KIRKLEES METROPOLITAN COUNCIL INVESTMENT & REGENERATION SERVICE

DELEGATED DECISION TO DETERMINE PLANNING APPLICATIONS

Reference No:	2024/62/92110/E
Site Address:	The Old Reading Rooms, The Village, Farnley Tyas, Huddersfield, HD4 6UQ
Description:	Change of use of domestic garage to office and alterations to roof pitch to create storage deck (within a Conservation Area)
Recommending Officer:	Elenya Jackson

24_811_101 B

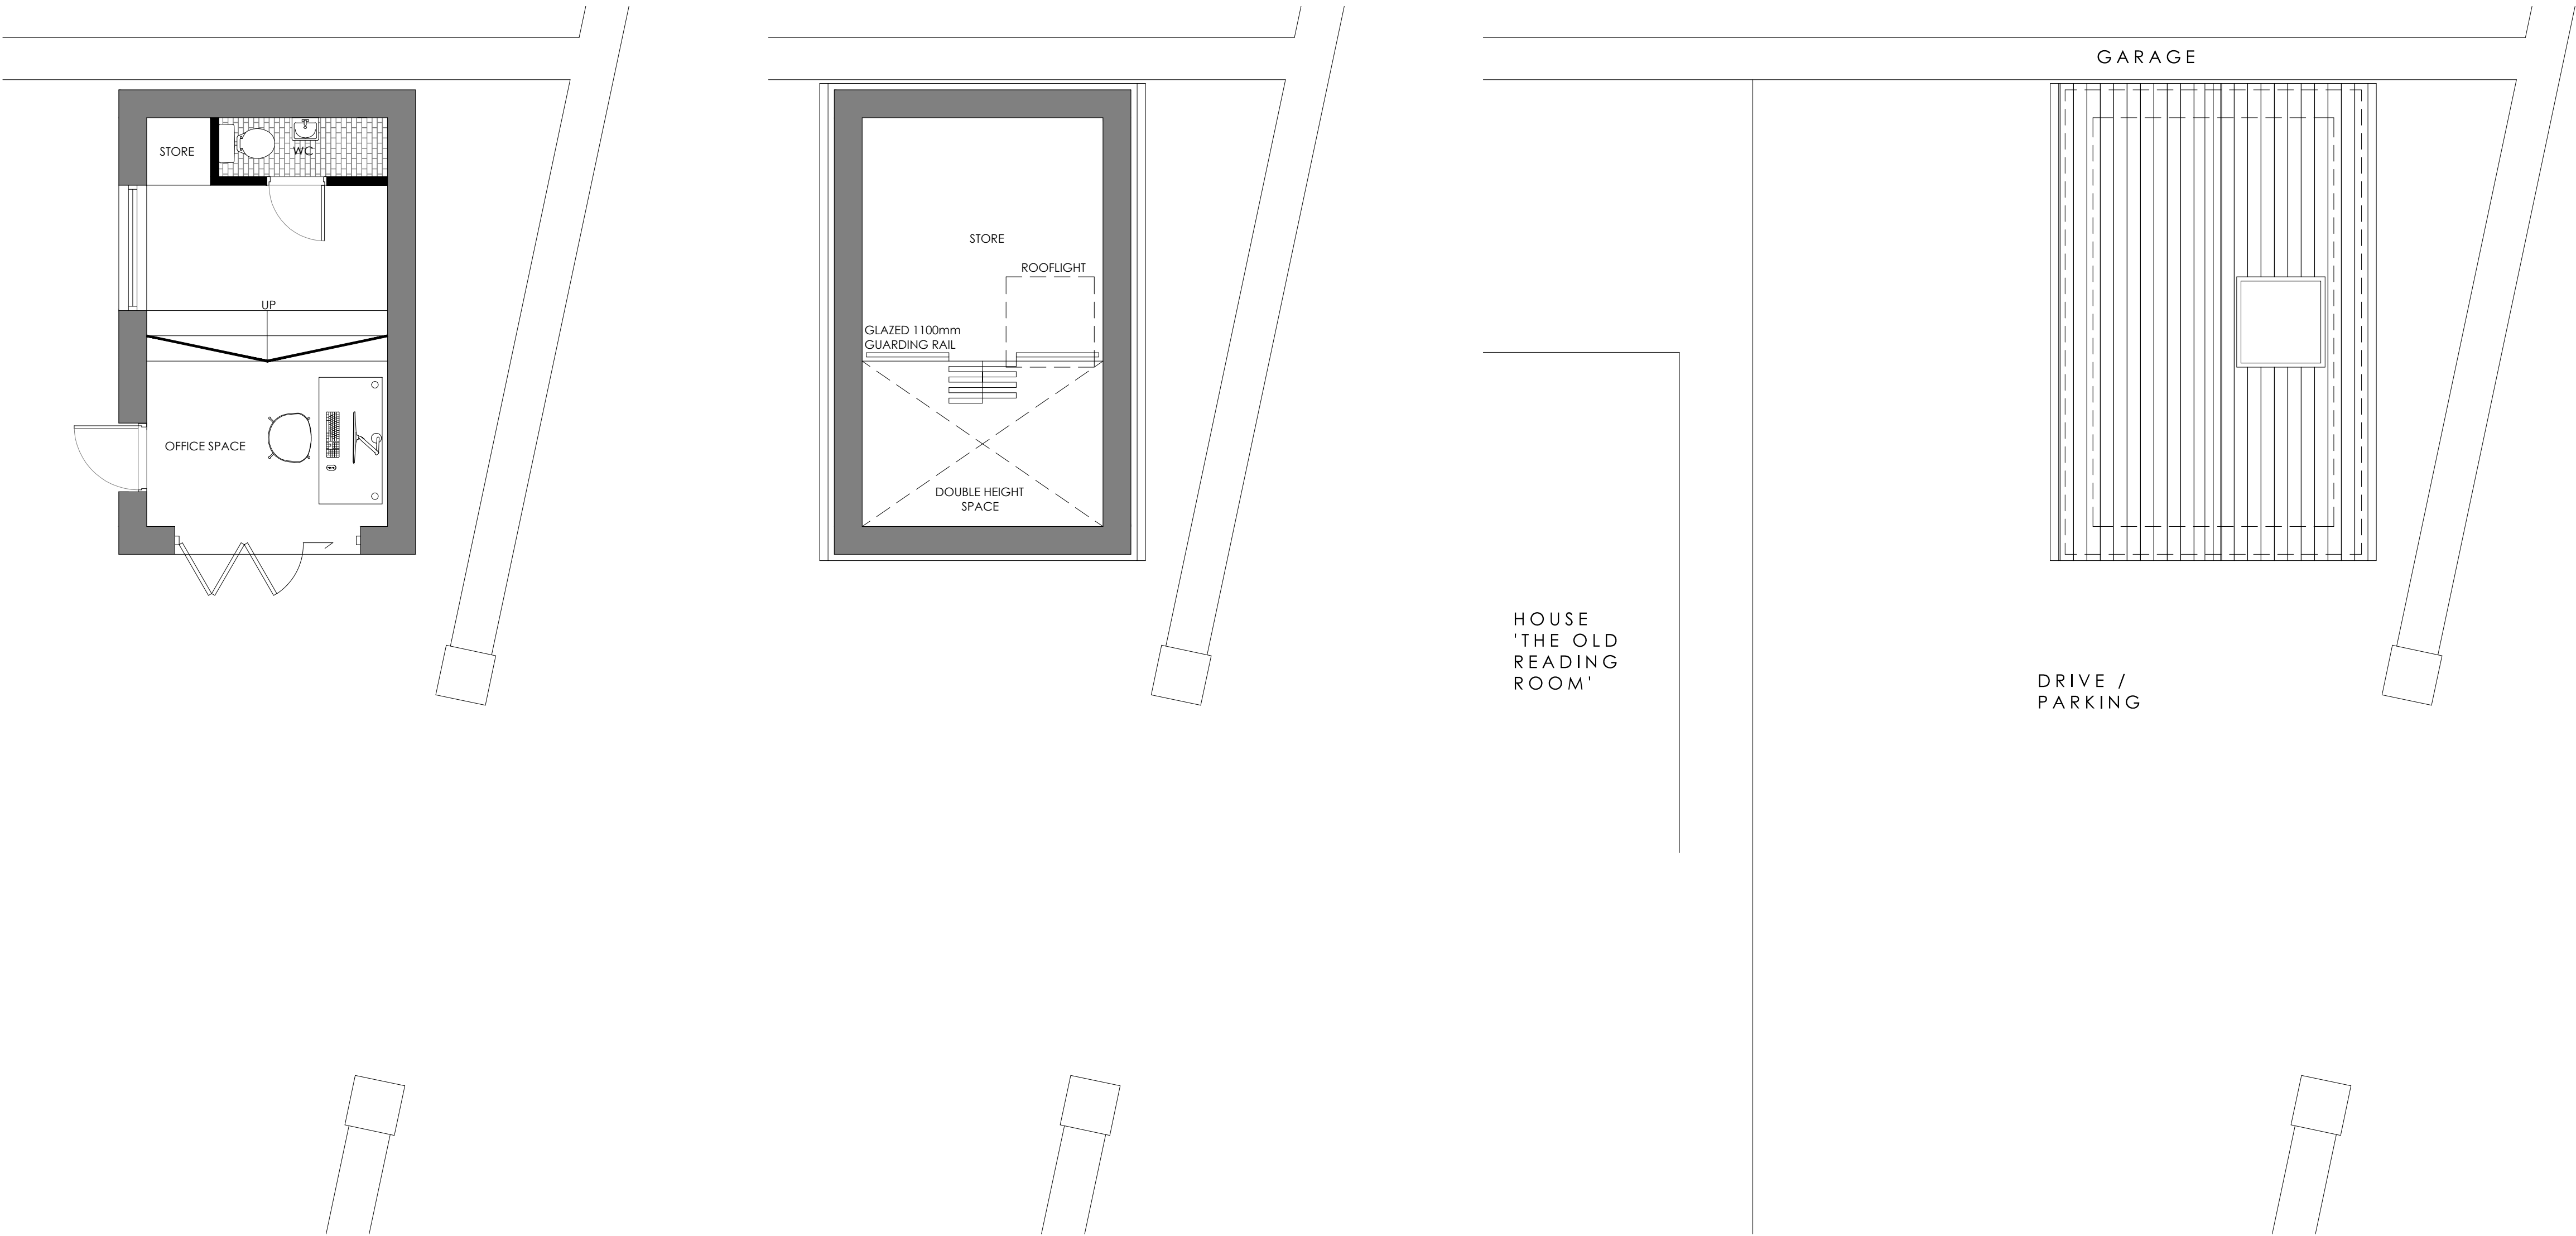
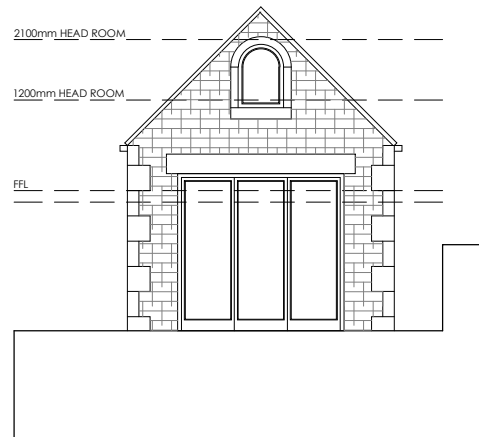
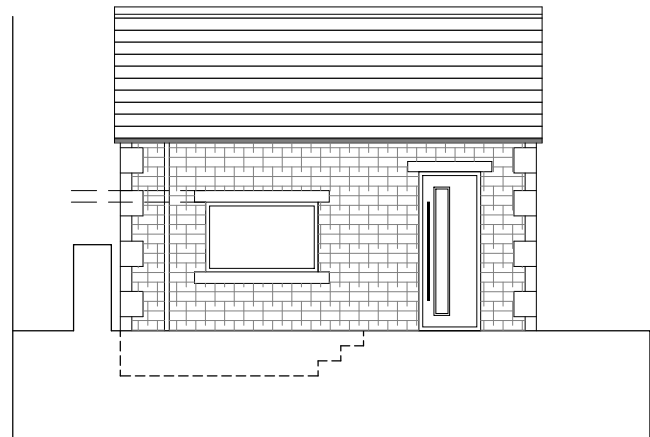
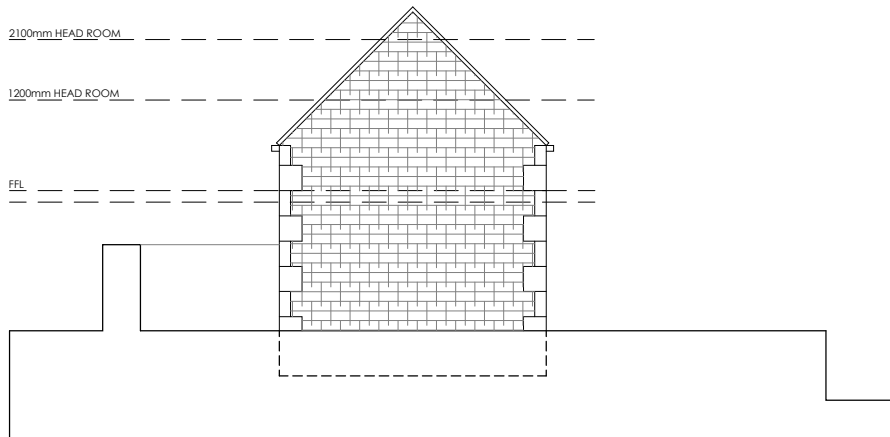
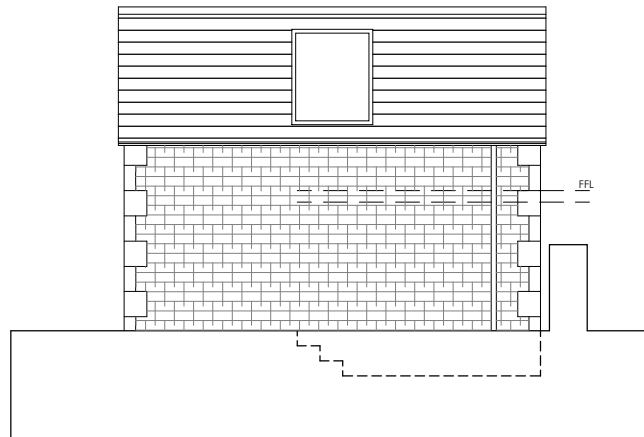
The footprint of the building would be retained, the eaves increased 10cm to 2.5m and the maximum height increased to 4.3m From 3.5m (down from 4.5m which was received at submission)

Conservation and Design: Informal discussion. Alterations requested during the course of the application to alter roof lights, reduce the height of the proposal and reduce the scale of fenestration.

The proposal would be marginally visible from the public realm of the conservation area due to its location. The northern elevation would be visible from the public realm which would be altered from a garage door to a bifold door with a small window above.

It is considered that following amendments to the scheme, the increase in height of the proposal would be marginal and that it would still appear subservient to the host dwelling due to its set back from the public realm and its footprint remaining consistent. In addition, there is a two-storey property set behind the application structure which would still be significantly larger than the proposed alterations. A street scene plan has been provided which demonstrates how the proposal would appear in the context of the site and it is considered the alterations are of an acceptable scale. The use of matching materials would aid the proposals integration with the street scene.

It is considered that due to the nature of the proposal, there would be a neutral impact on the conservation area and as such public benefit is not required. Officers consider that due to the eastern and northern elevation being visible in the public realm, a condition is necessary requiring the approval of the proposed windows and doors to ensure they are in-keeping and appropriate with the character of the conservation area.

Officers requested alterations to the scale and location of fenestration on the plans and a reduction in height. Additional plans we

3. Notwithstanding the details on the application form and submitted plans, prior to installation, details of all windows and doors at scale 1:20 shall be submitted to and approved in writing by the Local Planning Authority, and the development shall be constructed in accordance with the details approved and retained thereafter retained.
